El Paso County Parks

Agenda Item Summary Form

Agenda Item Title: Flying Horse North Filing No. 5 PUD Development Plan and Preliminary Amendment and Final Plat

Agenda Date: November 13, 2024

PUD PRELIMINARY PLAN MINOR AMENDMENT  
 LS PLAN

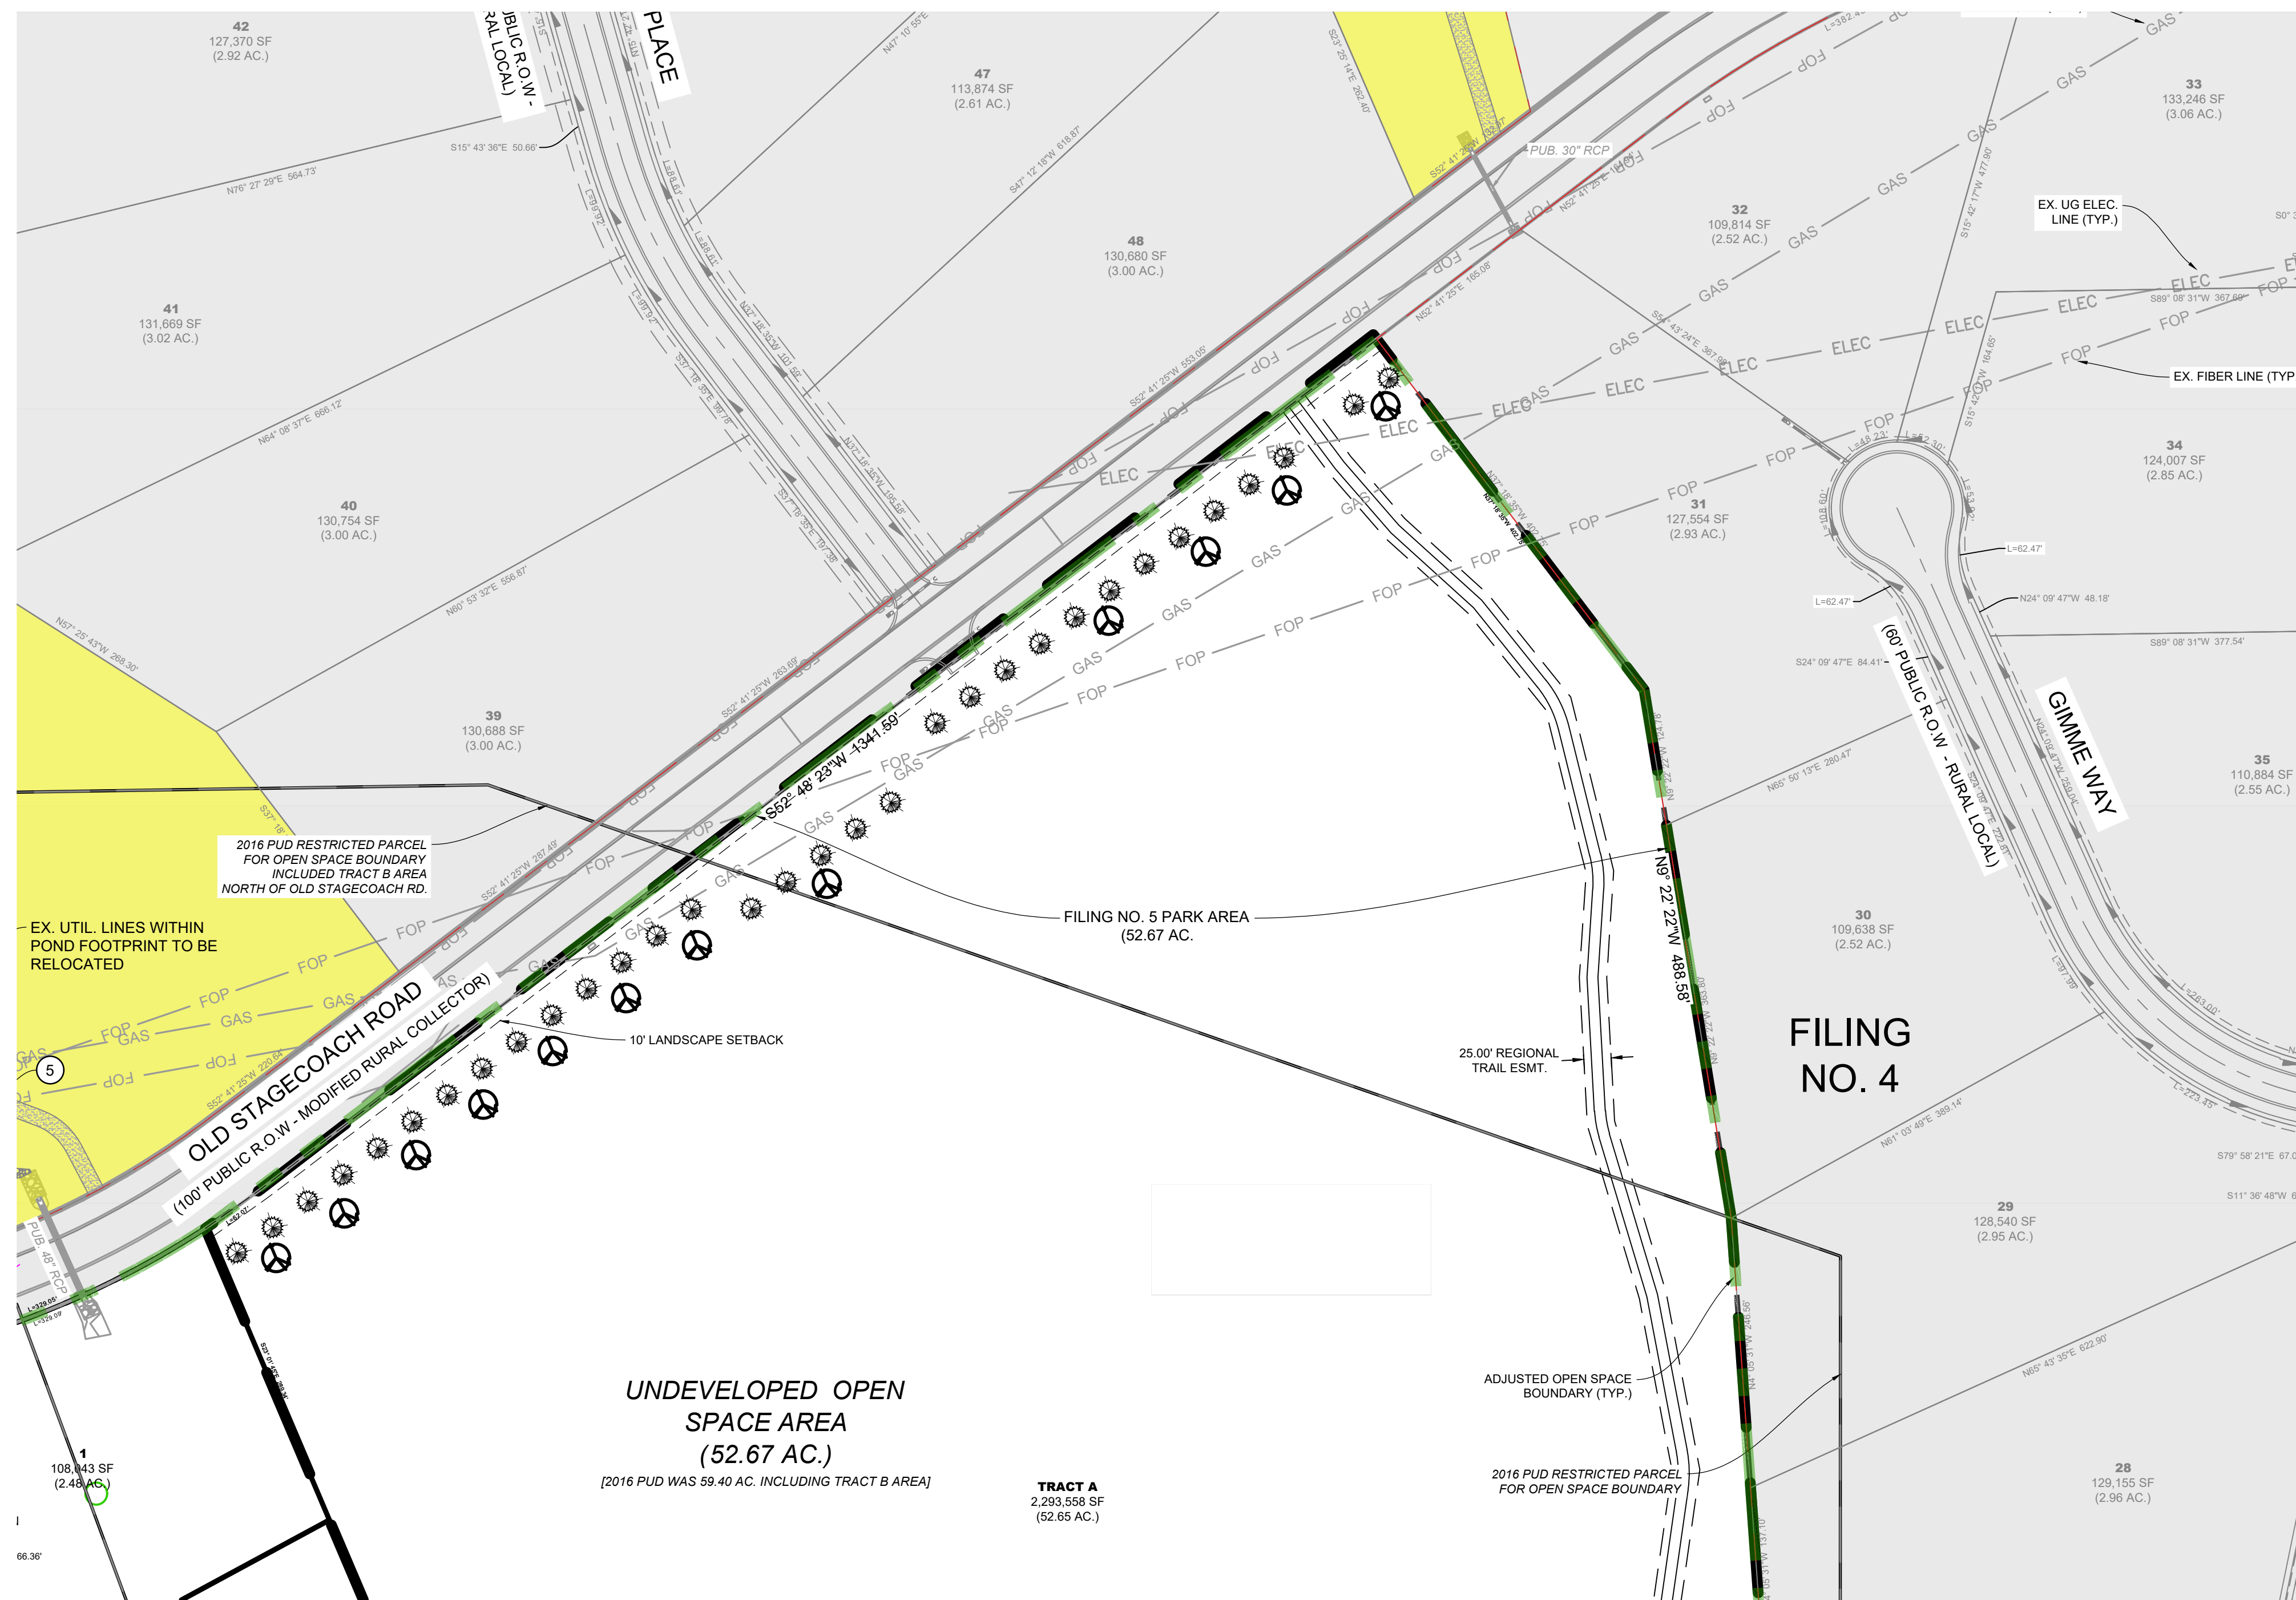
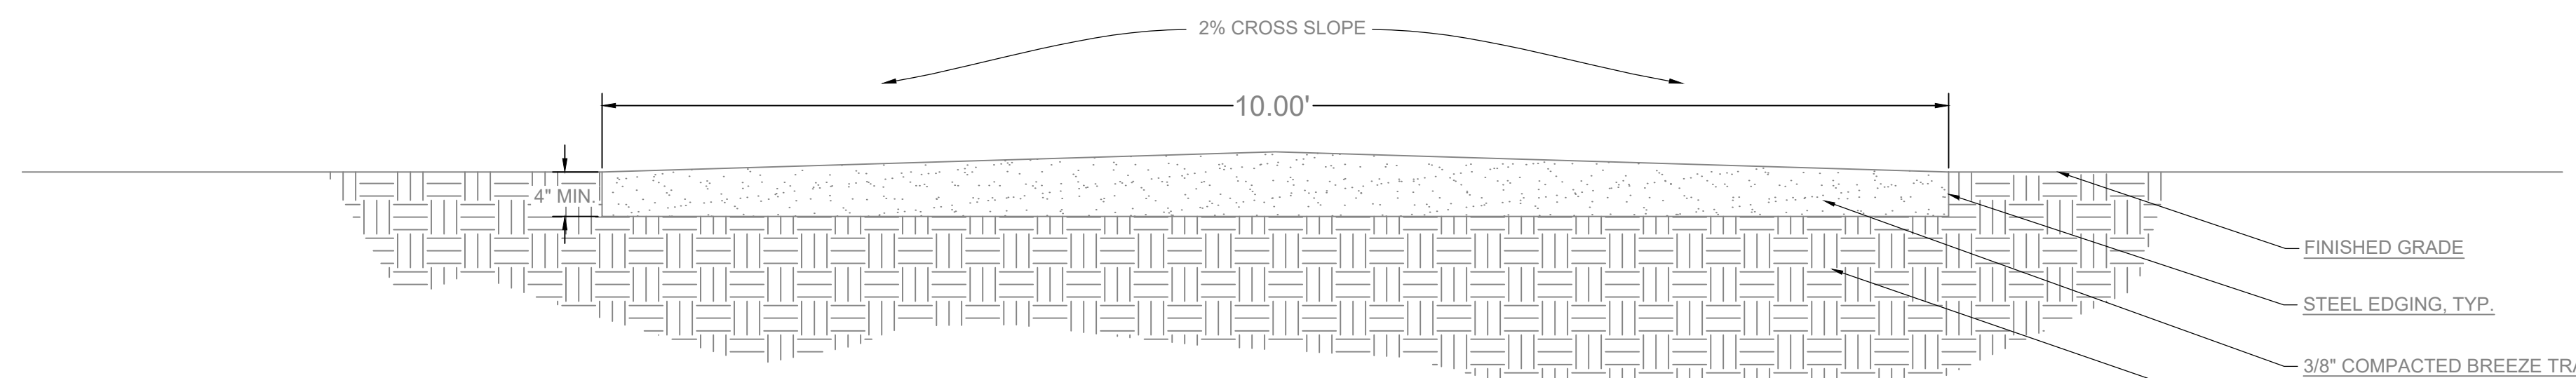
Furthermore, and as shown in the 2022 El Paso County Parks Master Plan, the Fox Run Regional Trail does traverse the northern boundary of Flying Horse North, following the south side of Hodgen Road as it travels to the west. The current Flying Horse North Trails Exhibit does not show this alignment and instead terminates the trail when it reaches Hodgen Road. Staff recommends the applicant add this particular section of the Fox Run Regional Trail to all future plans and final plats.

The Park Advisory Board recommends that the Planning Commission and the Board of County Commissioners include the following conditions when considering and/or approving the Flying Horse North Filing No. 5 PUD Development Plan and Preliminary Plan Amendment: (1) add the missing section of the Fox Run Regional Trail conceptual alignment to the Flying Horse North Trails Exhibit, located along the south side of Hodgen Road, terminating at the northwesternmost corner of the development; (2) designate and provide to El Paso County 25-foot wide public regional trail easement through Filing No. 5 that allows for public access, as well as construction and maintenance by El Paso County of the Fox Run Primary Regional Trail, and the easement be shown, noted, and dedicated to the County via the forthcoming Final Plat; and (3) fees in lieu of land dedication for regional park purposes in the amount of \$10,605 will be required at time of the recording of the forthcoming Final Plat. A Regional Trail Agreement may be acceptable alternative to regional park fees, provided the agreement is submitted by the applicant, reviewed and approved by the County, and executed prior to recording the Final Plat.
